APPLICATION **BR/227/18/PL**

Site Address: 1-2 Lyon Street Bognor Regis PO21 1DA

Description of Demolition & erection of storage unit with flat roof

TO:	Arun District Council FAO: Stuart Corbey
FROM:	Highways, WSCC
DATE:	28 th November 2018
LOCATION:	1-2, Lyon Street, Bognor Regis, PO21 1DA
SUBJECT:	BR/227/18/PL Storage unit with flat roof.
RECOMMENDATION:	☒ Advice ☐ Objection ☐ Modification ☐ No Objection ☒ More Information ☐ Refusal
S106 CONTRIBUTION TOTAL:	£N/A

PROPOSED PLAN
LYON STREET, BOGNOR REGIS, WEST SUSSEX.

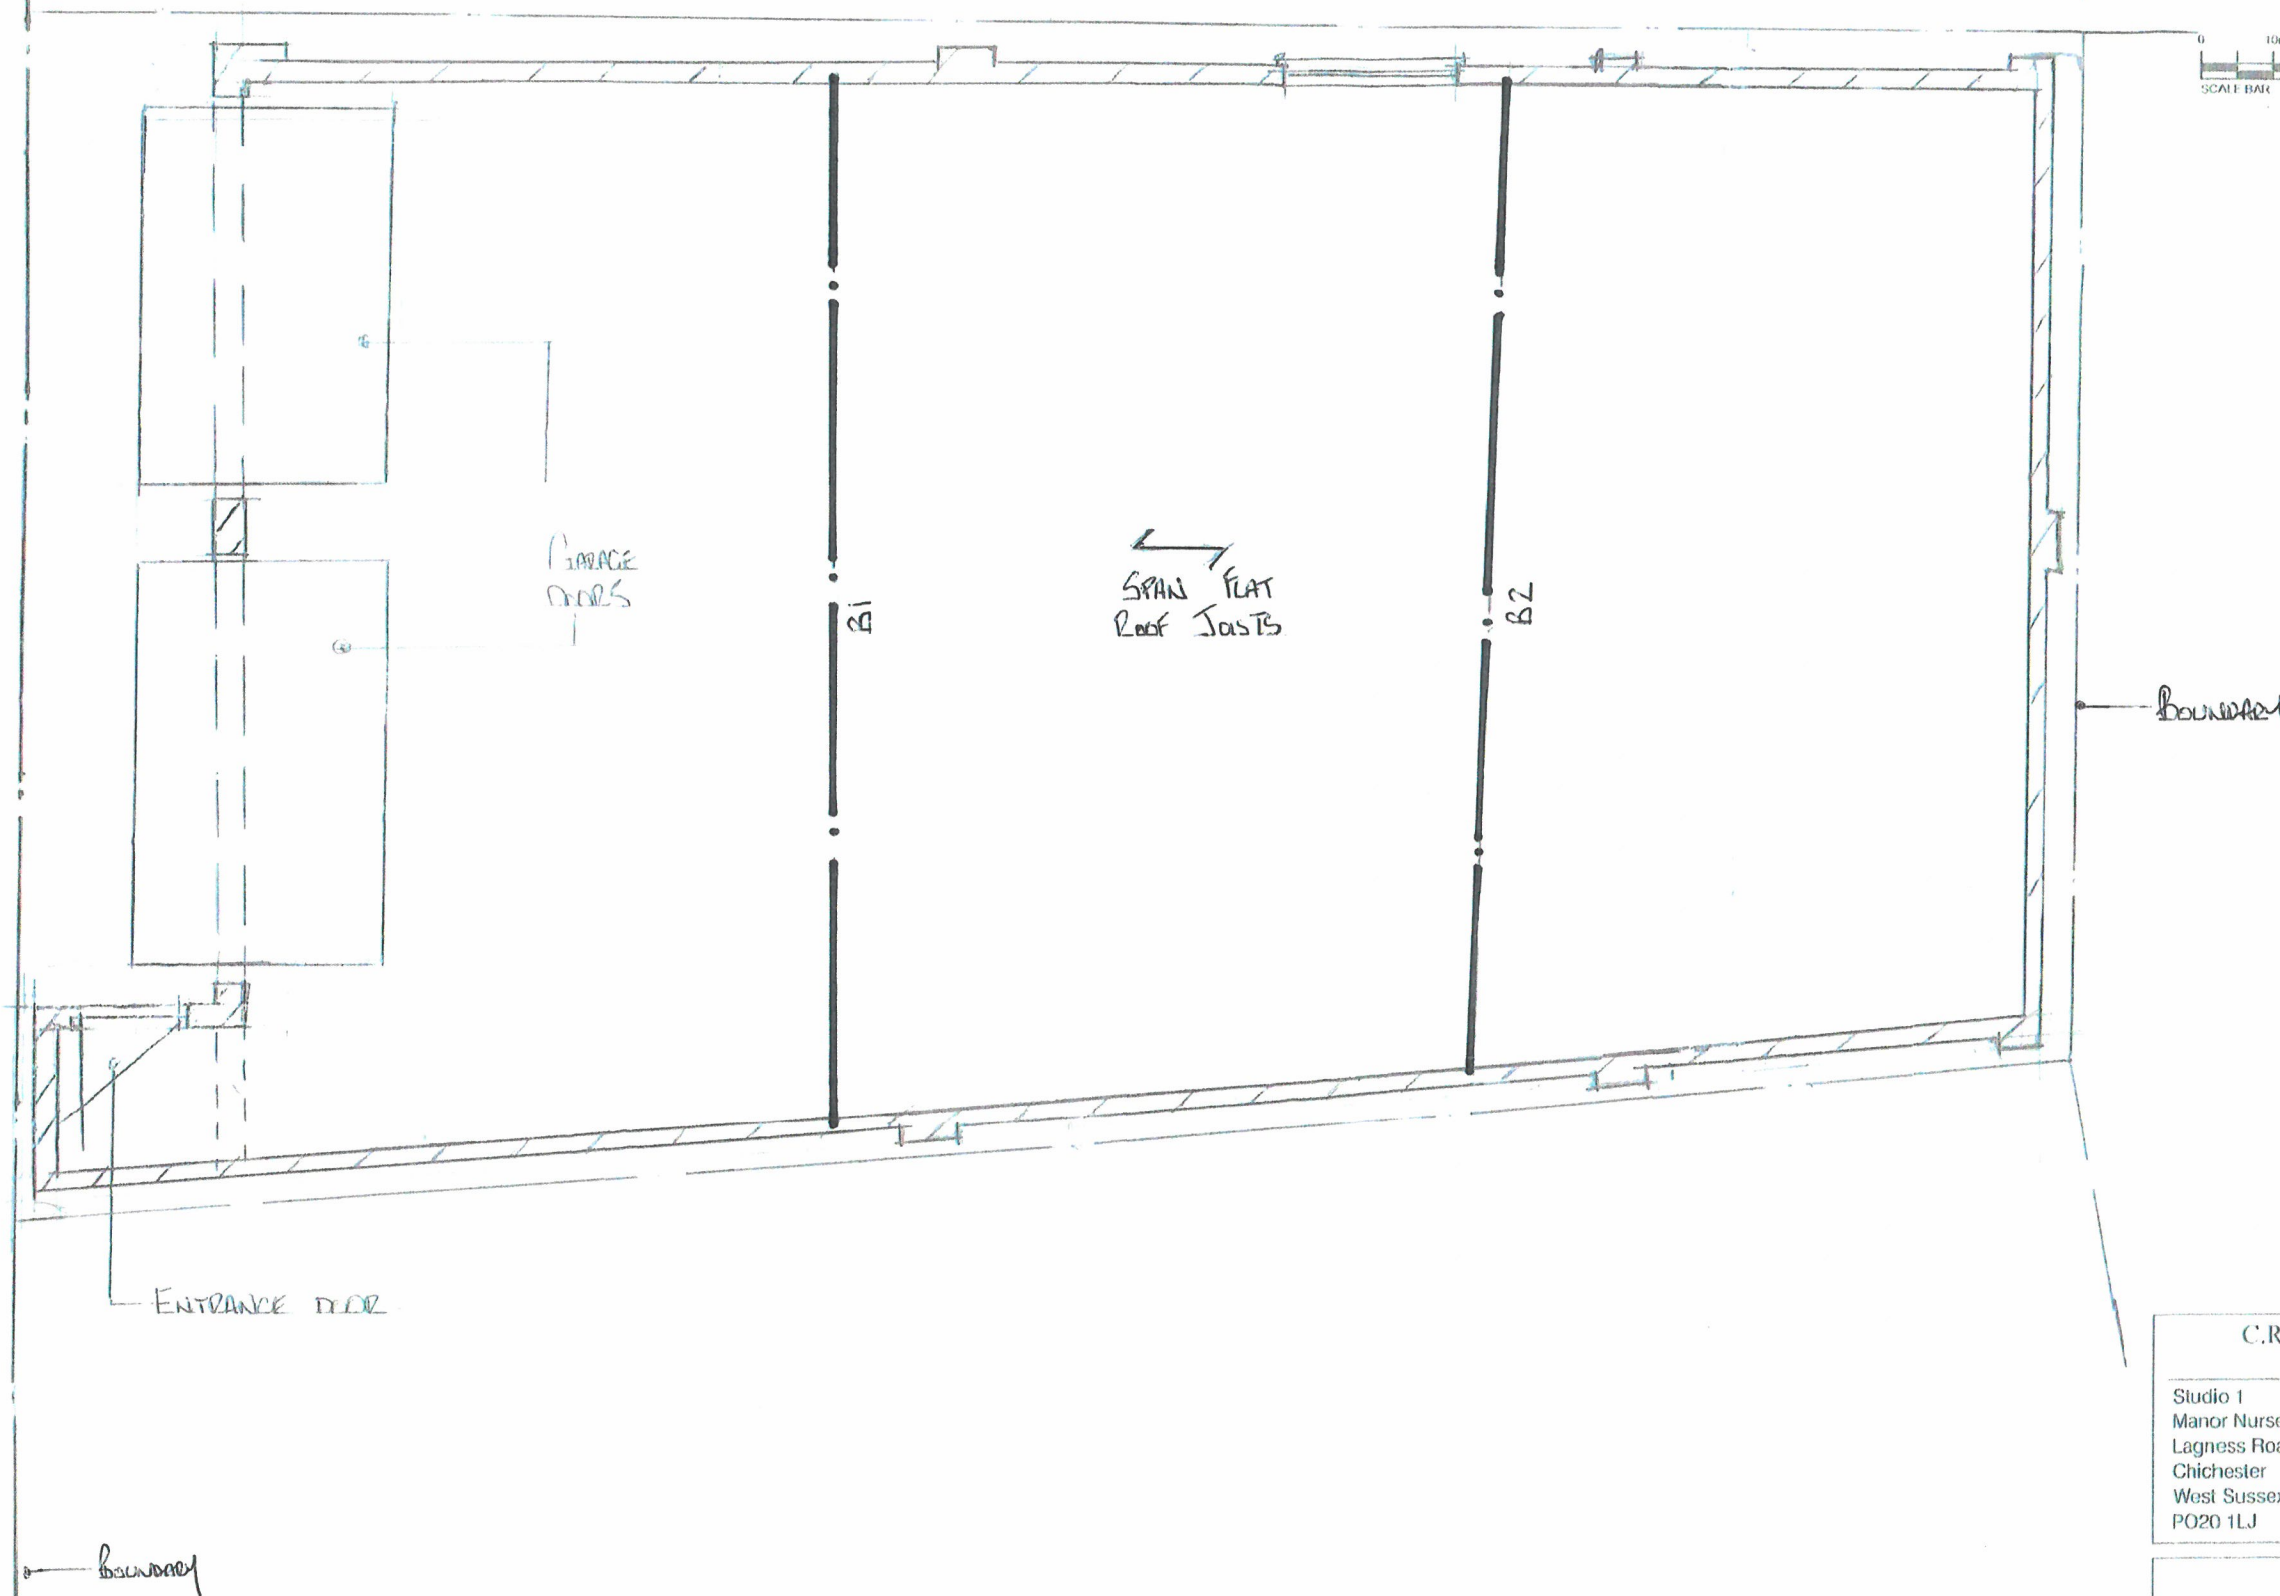
The plans appear to show the existing garage being retained. If the garage and off-street parking is to be removed from the site then the dropped kerb should be reinstated if no off-street parking is proposed. Please ask the applicant to clarify this point and provide proposed plans, including any alteration/ removal of car parking.
